STATE OF NORTH CAROLINA  
DEPARTMENT OF TRANSPORTATION

November 04, 2020

Subject: **Request for Modification to Individual Section 404 and Section 401 Water Quality Certification** for the Winston-Salem Northern Beltway from US 52 to US 311 (New Walkertown Road), Forsyth County. Federal Aid Project No. NHP-0074(213), TIP Nos. U-2579D, E& F. Division 9.

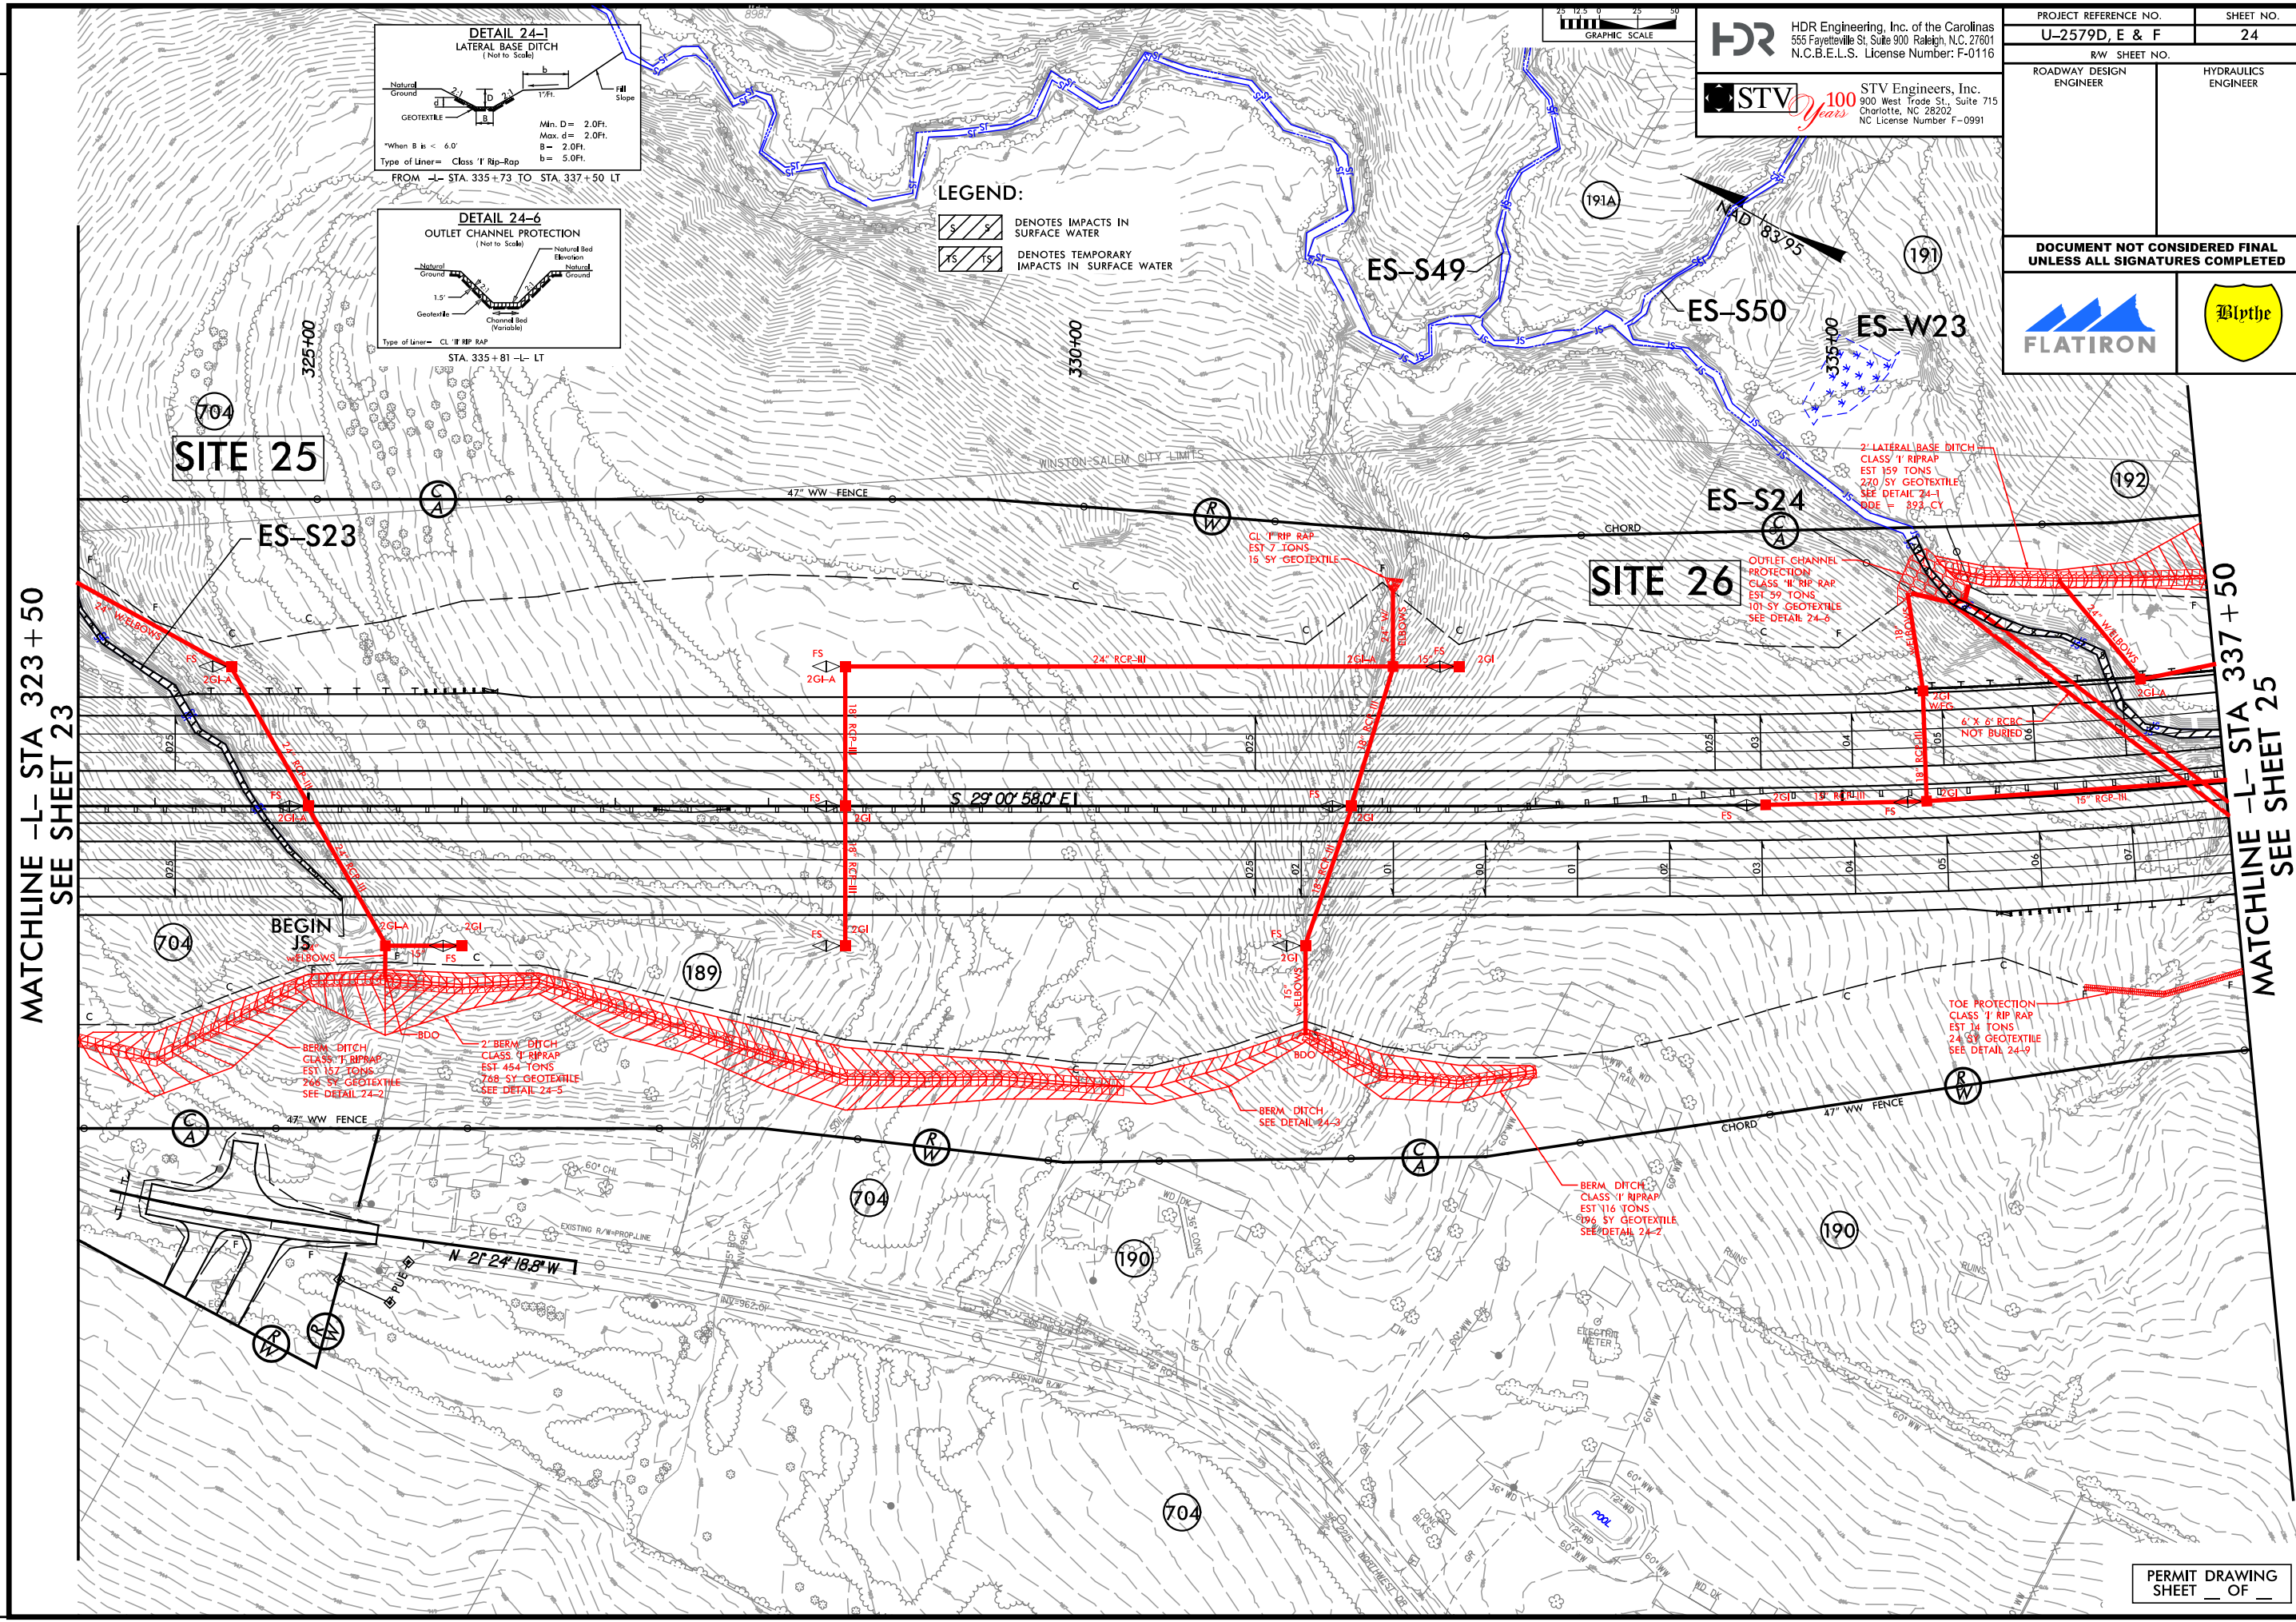
Site 26 (Roadway Plan Sheets 24/25): Site 26 impacts have not changed from the modification dated January 2020; however, the design has changed due to the noise walls. A ditch is required along the toe of fill that will tie to the existing bank stabilization at the inlet of ES-S24. The updated plan sheets are attached.
